APPENDIX B – CONSULTANT RESPONSES

Re: Response to Comments from the NSW Department of Planning - Newcastle Private Hospital Extensions, Lookout Road, New Lambton Heights, NSW.

ADDENDUM - RESPONSE TO NEWCASTLE CITY COUNCIL'S CONCERNS NEWCASTLE PRIVATE HOSPITAL EXTENSIONS

Newcastle Private Hospital - BTF Responses to Public Consultation comments.

Figure 2 – Development Traffic trip distribution

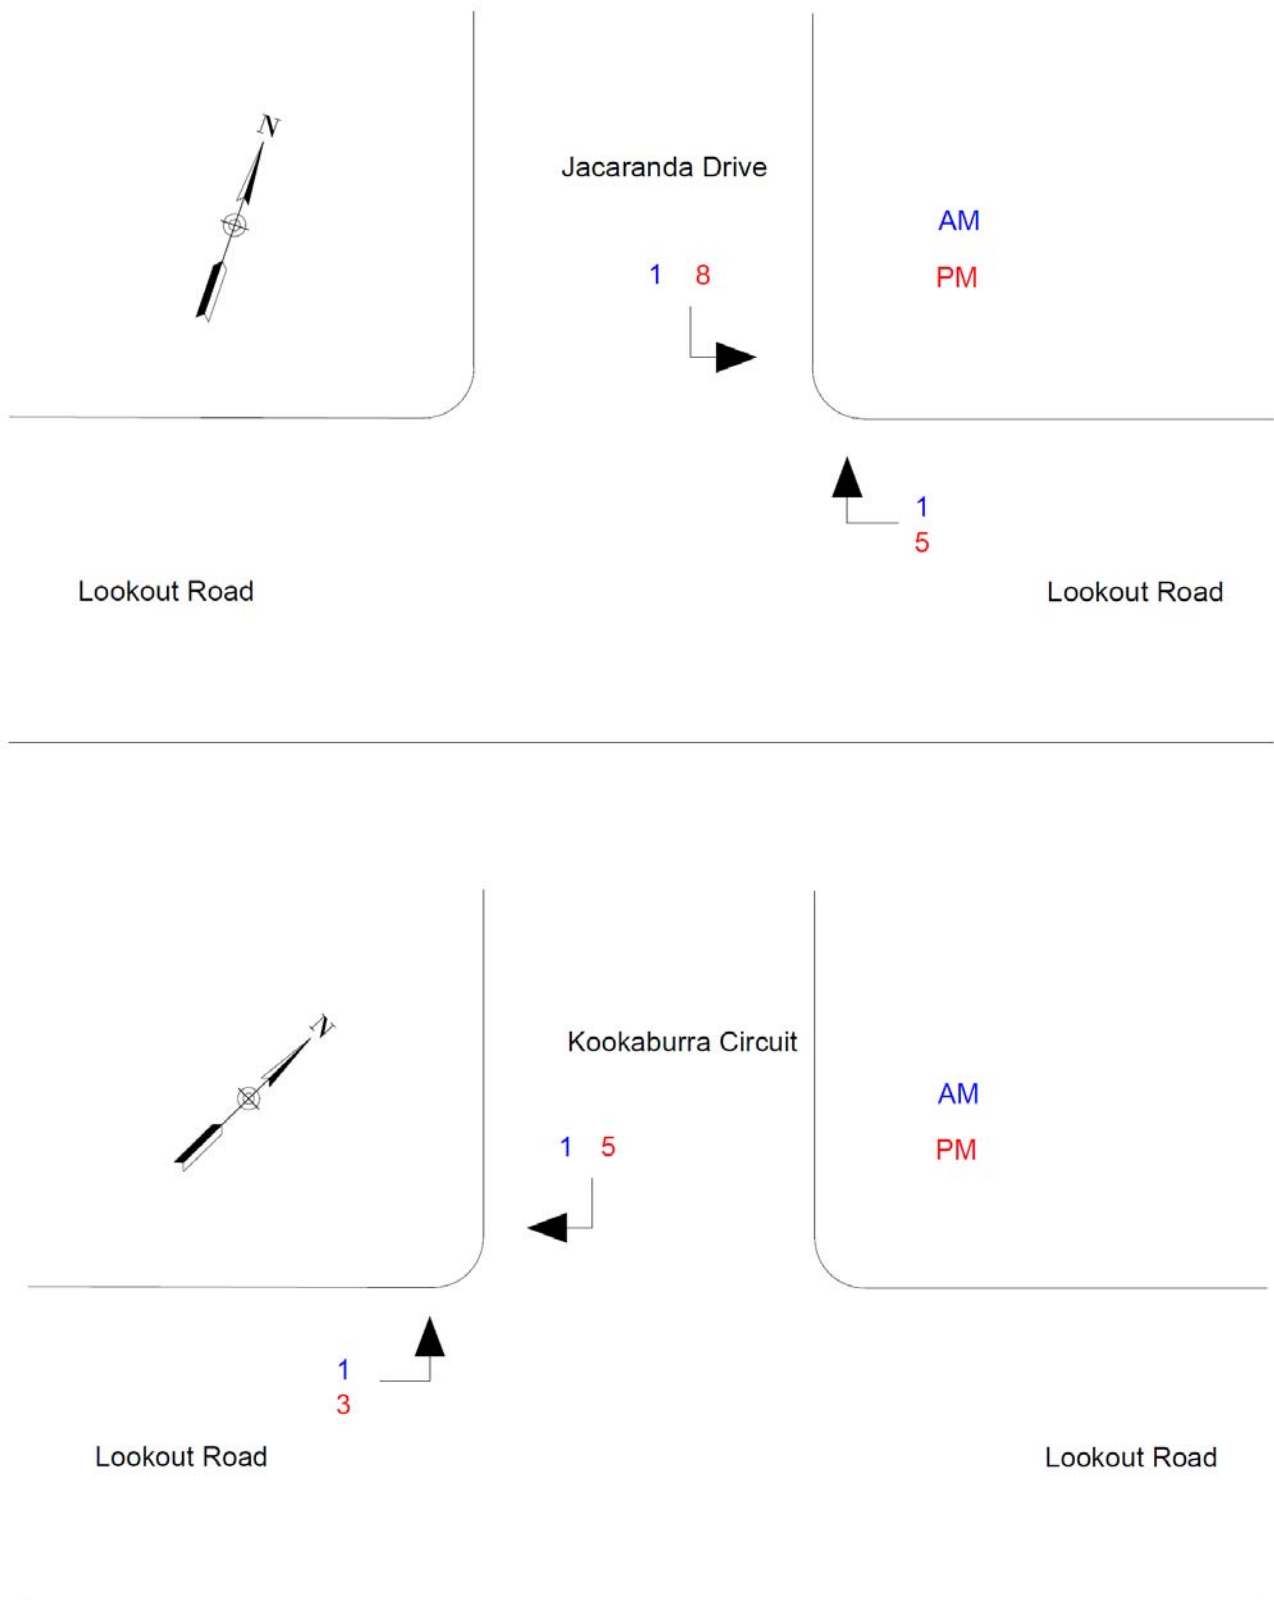
- **Access:** Deceleration lane /queuing length. AS2890.1:2004 sets the minimum requirements for queuing lengths at a car park with control points at the entrance, Ref Table 3.3. This indicates a requirement of 7 vehicles storage for a 400 bay car park. This, however, assumes all vehicles will access the car park by this access. In the situation of the Private Hospital there are two access points and it is expected that drivers, staff, patients and visitors approaching the Hospital from areas to the south and west (northbound on Lookout Rd) will turn right into Tea House Rd and enter the car park via the

existing access. A queuing length of 34m can be achieved when measured from the boom gate to the taper at the proposed Jacaranda Drive access and approximately 20m of queuing exists at the existing access. This will provide queuing for up to 9 vehicles.

A taper of 28m has been provided at the proposed Jacaranda Drive access, to allow for vehicles to slow down when entering the car park.
